70 Anderson St Initial Workshop Feedback

For 70 Anderson workshop, the developer Jonathon Culley is asking for four waivers all ready knowing the current ordinances. The four waivers are:

DRAWING NO. **C-10**

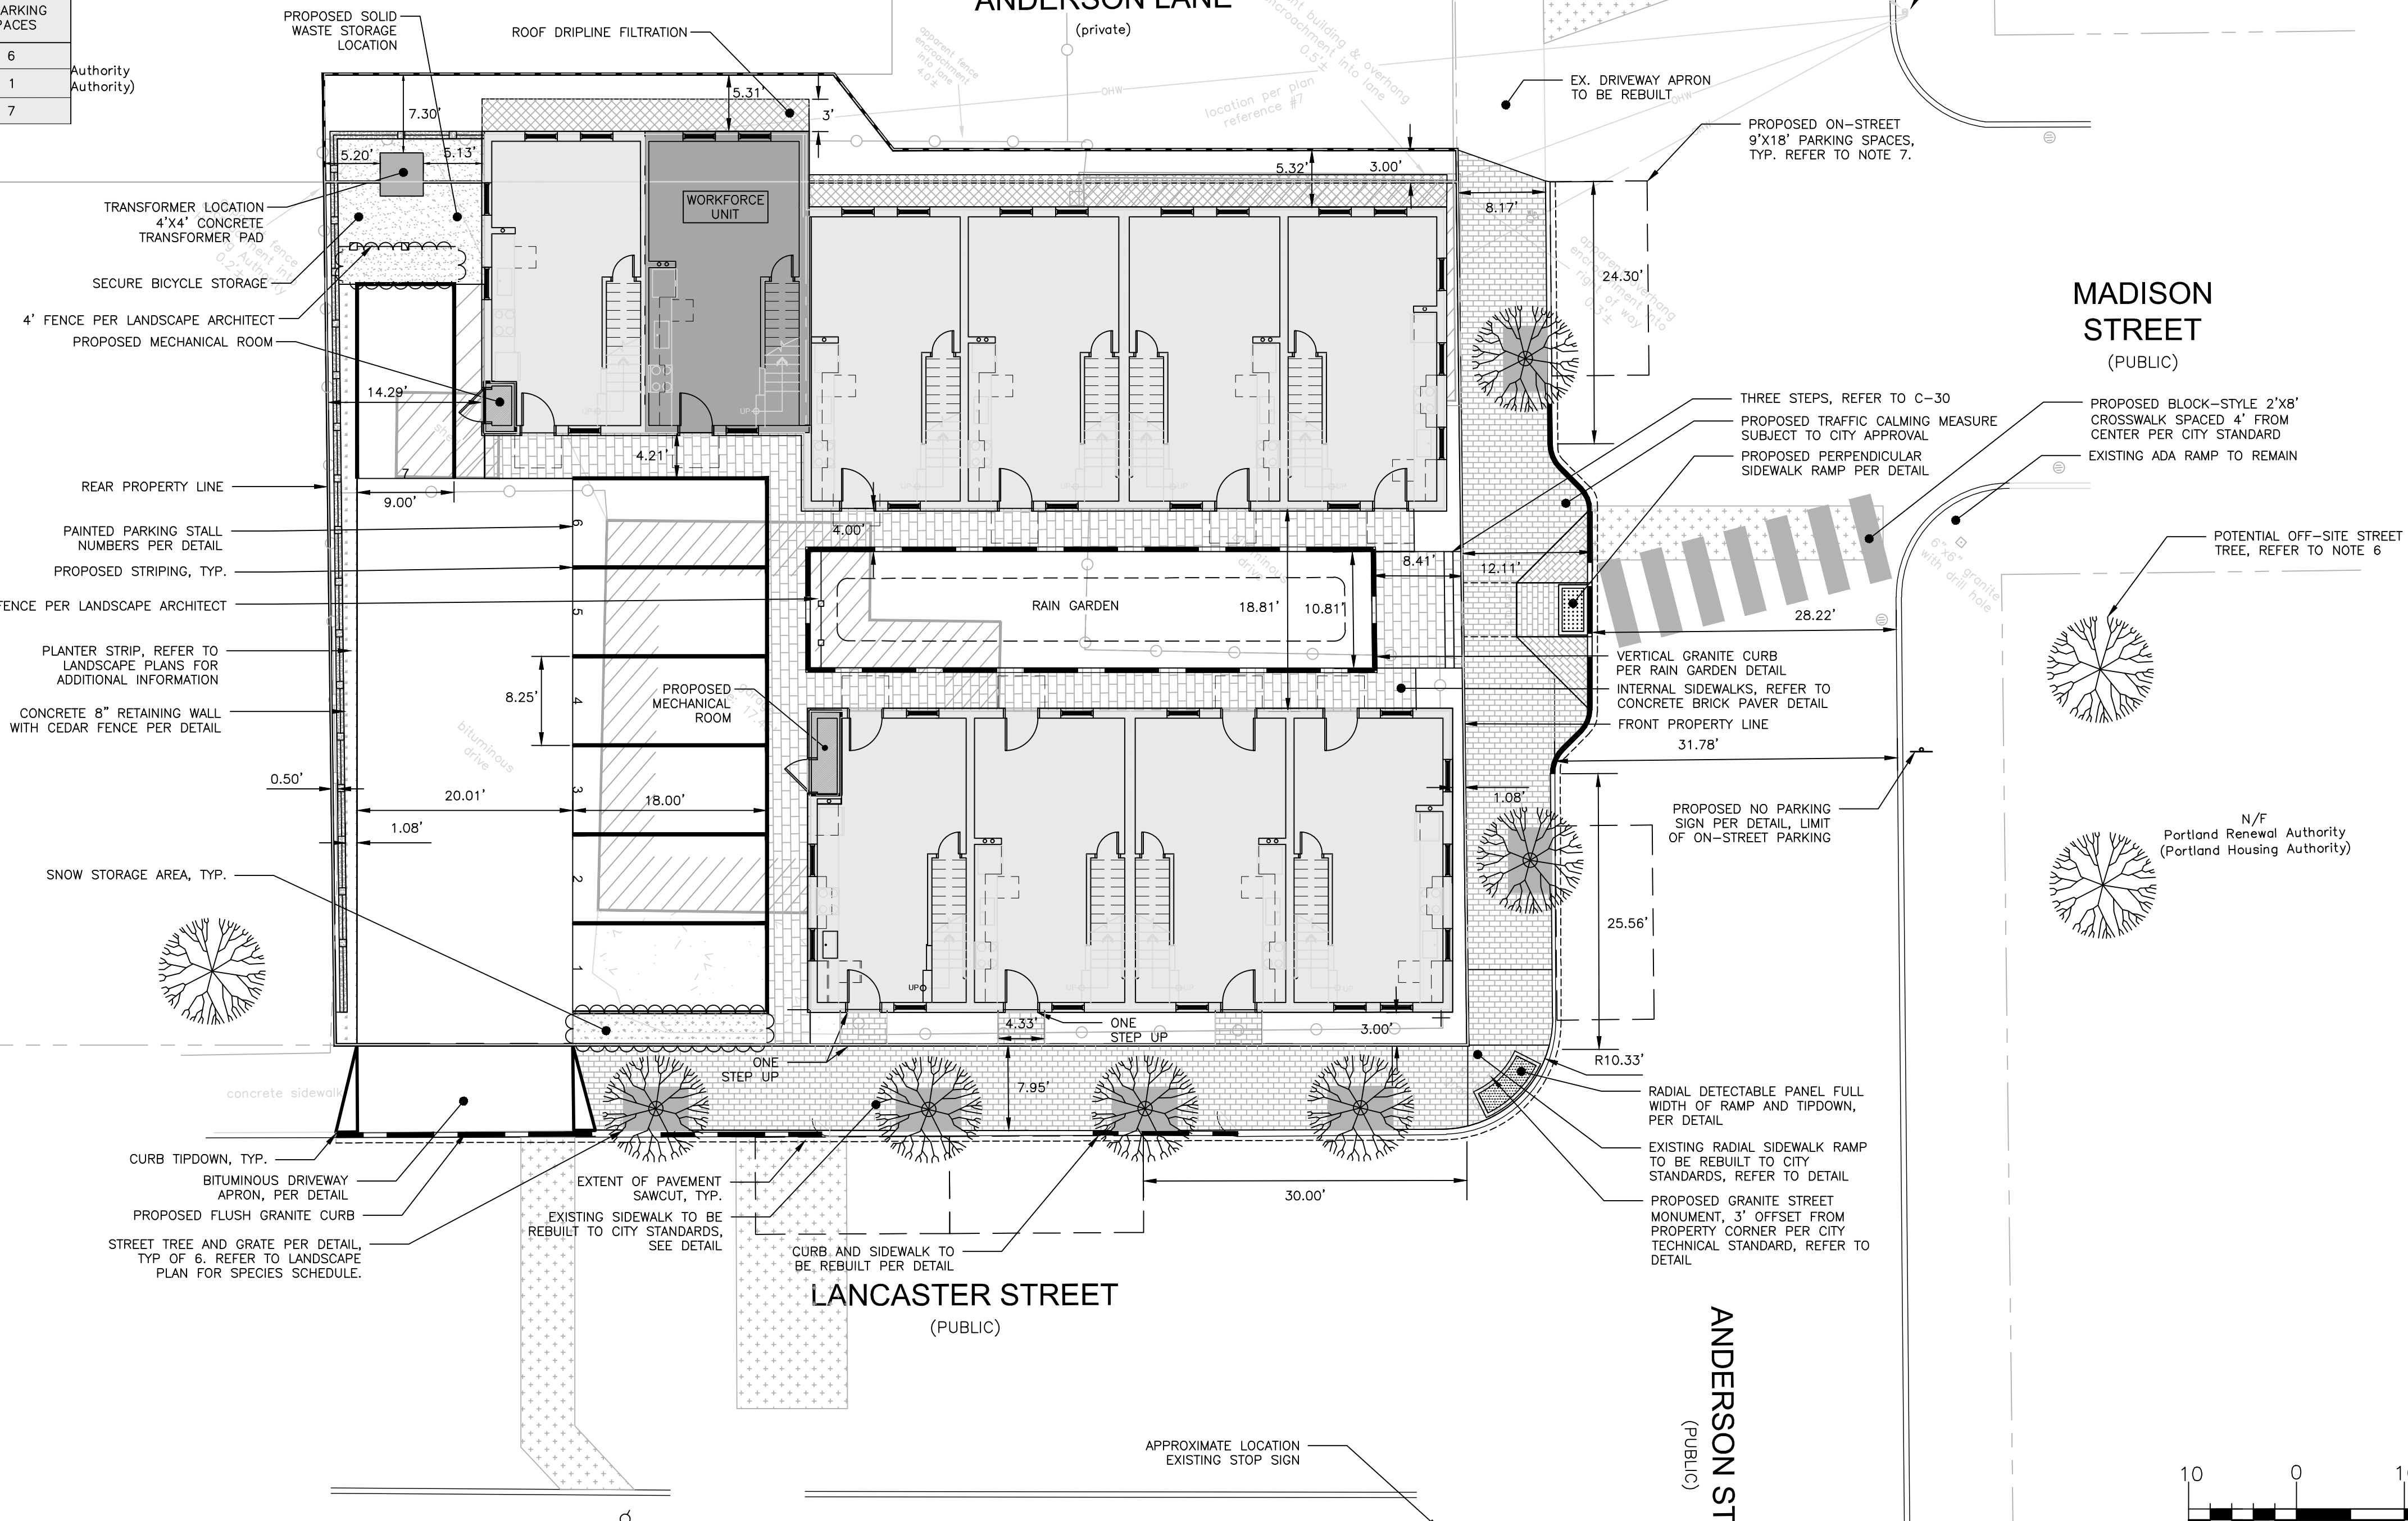
1. The 7 parking spots are only large enough for compact cars. Would families that can afford these 3 bedroom townhouses really have compact cars? More like SUVs.
- Of course he only put in the minimum parking spaces based on the latest changes in the R6 on parking where it is not required to put in parking spots for the first 3 units.
2. The required street trees for this project is 10. He can only fit 4 on Anderson street sidewalk and no street trees on Lancaster St because the sidewalk is too tight because the townhouses are too big. But don't worry, he will have 6 trees between the buildings and he thinks this should qualify for street trees. No, six trees inside a property does NOT qualify as a street tree.
3. Not enough room for parking landscaping due to the tight spaces.
4. Lack of aisle way for entrances.

1. The adjoining neighbor who wants to put solar panels on roof and Culley's design could potentially block the sun for this neighbor.
2. The adjoining neighbors concern of the abatement of these buildings and how it will affect his children and the garden where he grows his vegetables.
3. Yet once again concern of affordable housing of Jonathan Culley and the minimum requirement of having one affordable house on this site based on the Ensure Workforce Housing Fairness Act.
4. The 4 waivers which the Planning Board didn't seem to concerned with and the impression that they will be waived quite easily these waivers for not having properly sized parking spaces, lack of parking landscaping, and the lack of street trees.
